**Pick n Payless Metal Recovery and Recycling Facility (SSD-8375)
Response to Submissions**

PICK N PAYLESS METAL RECOVERY AND RECYCLING FACILITY (SSD-8375)
DEPARTMENT OF PLANNING, INDUSTRY AND ENVIRONMENT – KEY ISSUES

Plan No.
CC160136-1-101

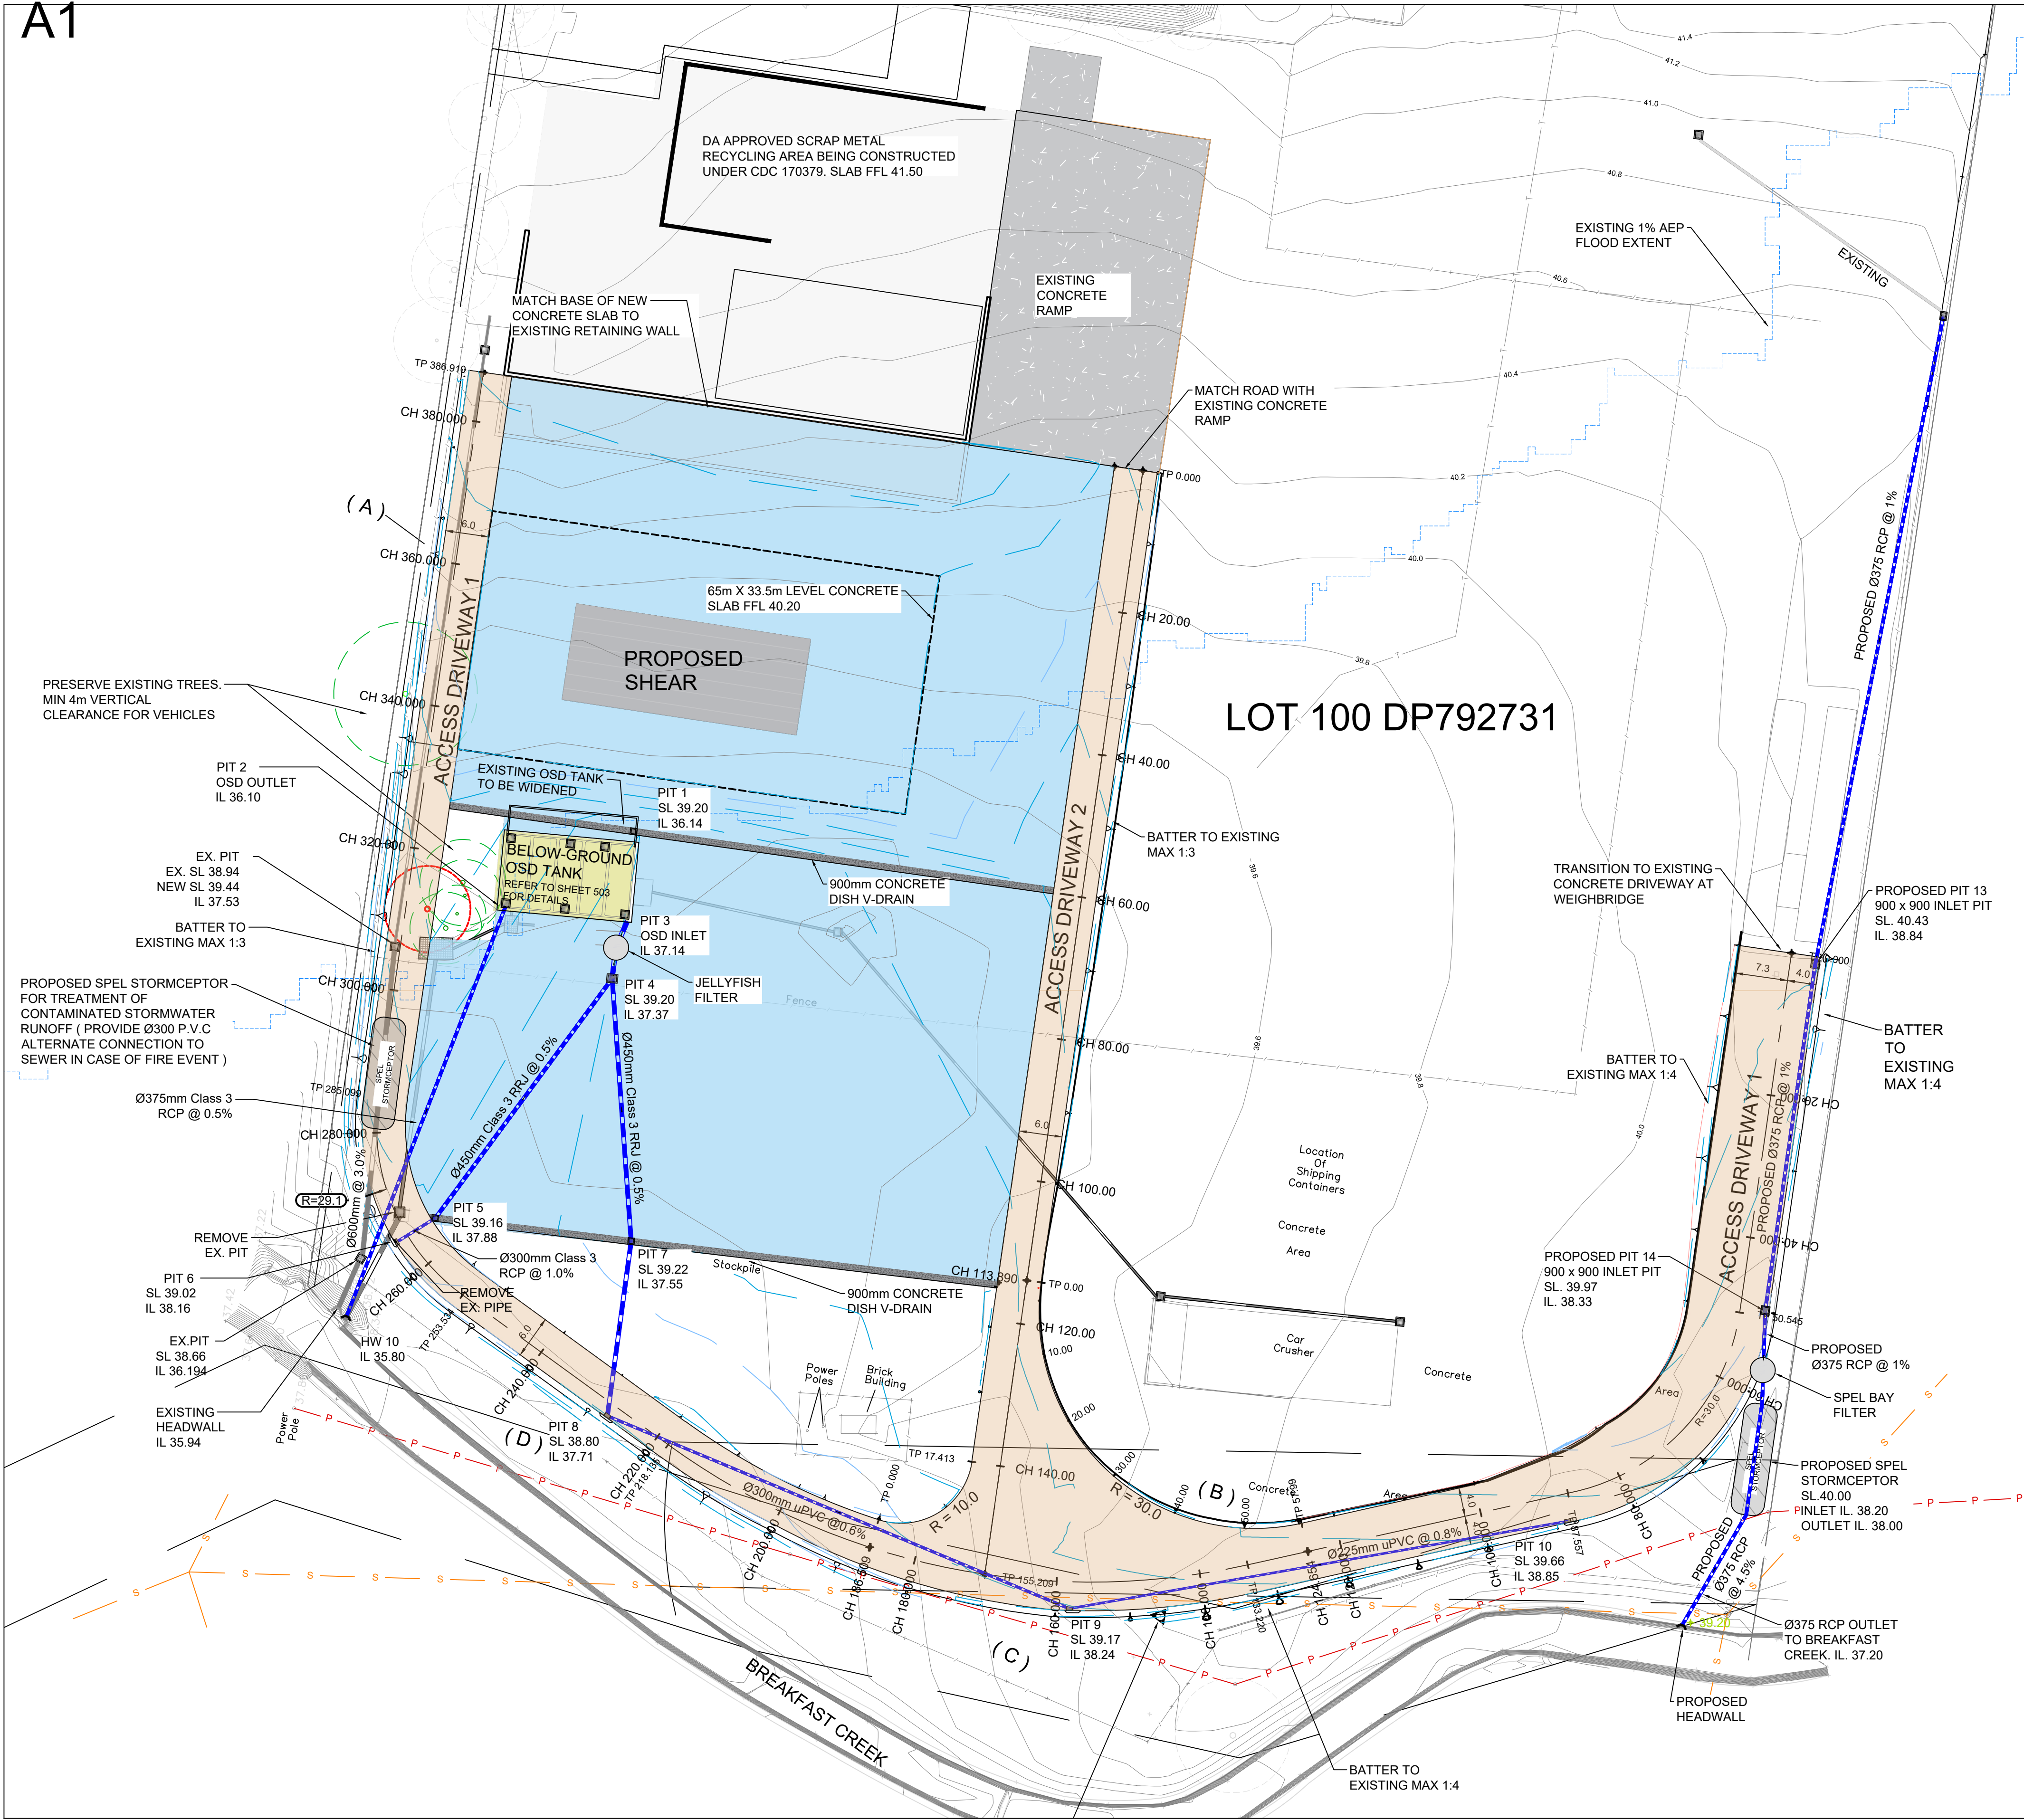
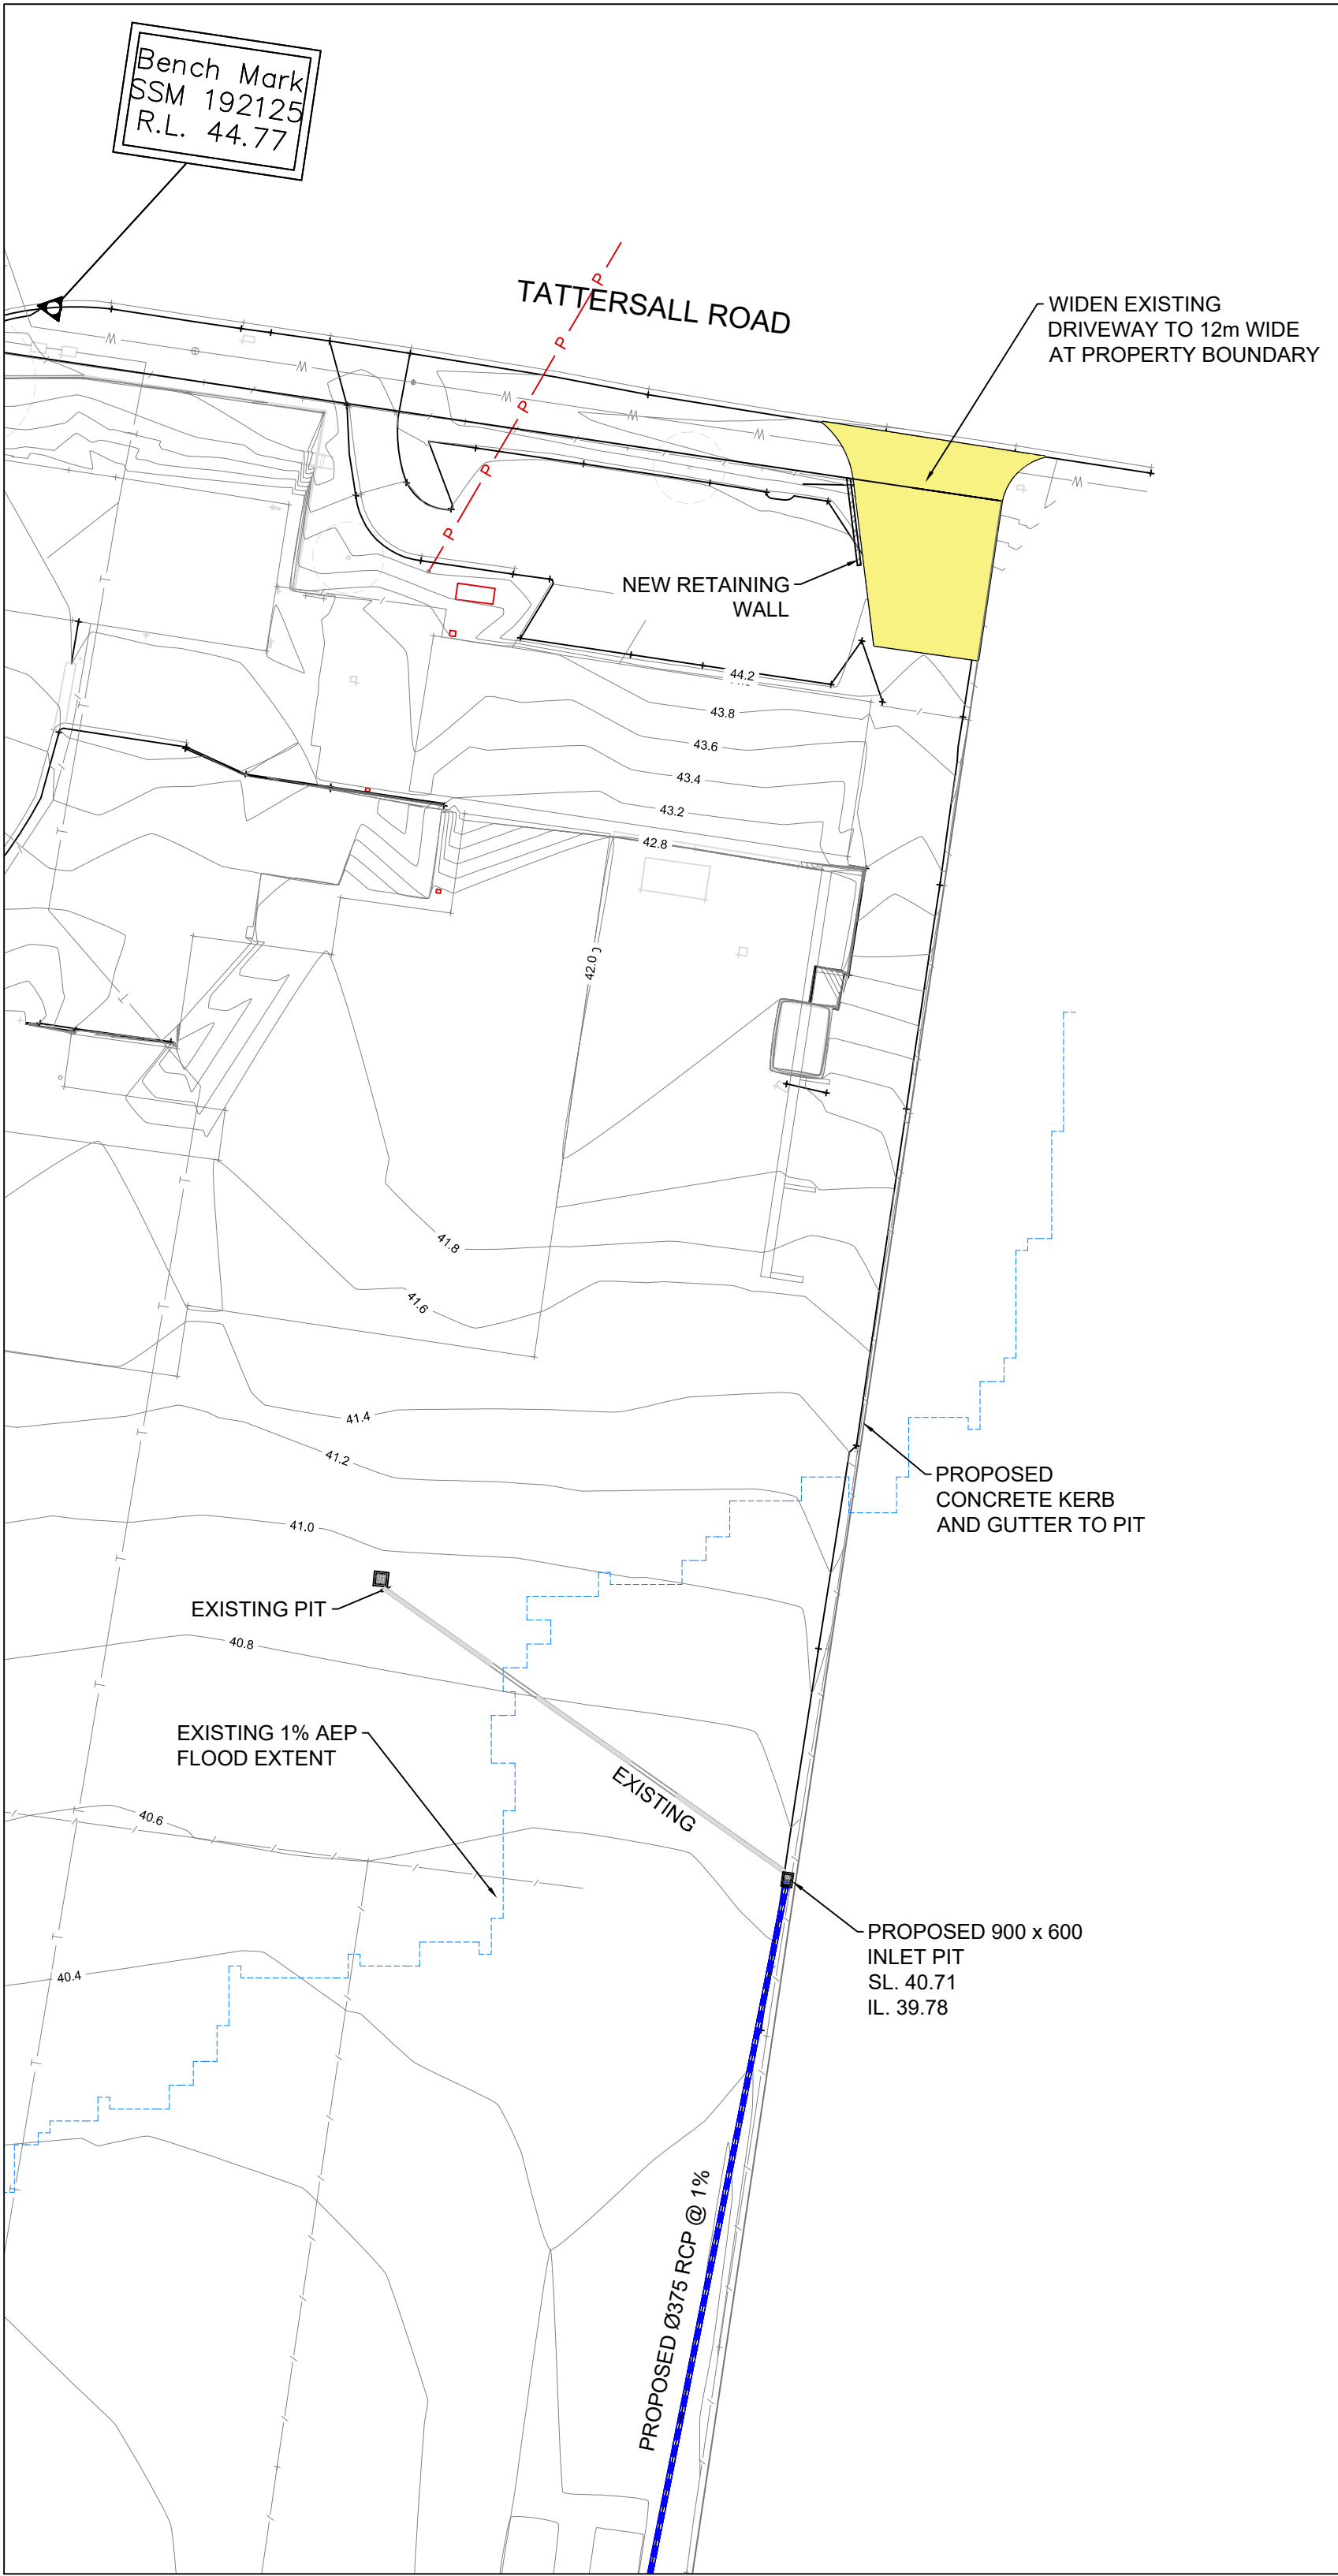
9. The Site Plan (CC160136-DA Sheets, Revision A) in the SWR shows a SPEL Stormceptor (to the south-west of the below-ground OSD pond) will be installed for treatment of contaminated stormwater runoff. Please provide the capacity of the proposed SPEL Stormceptor.
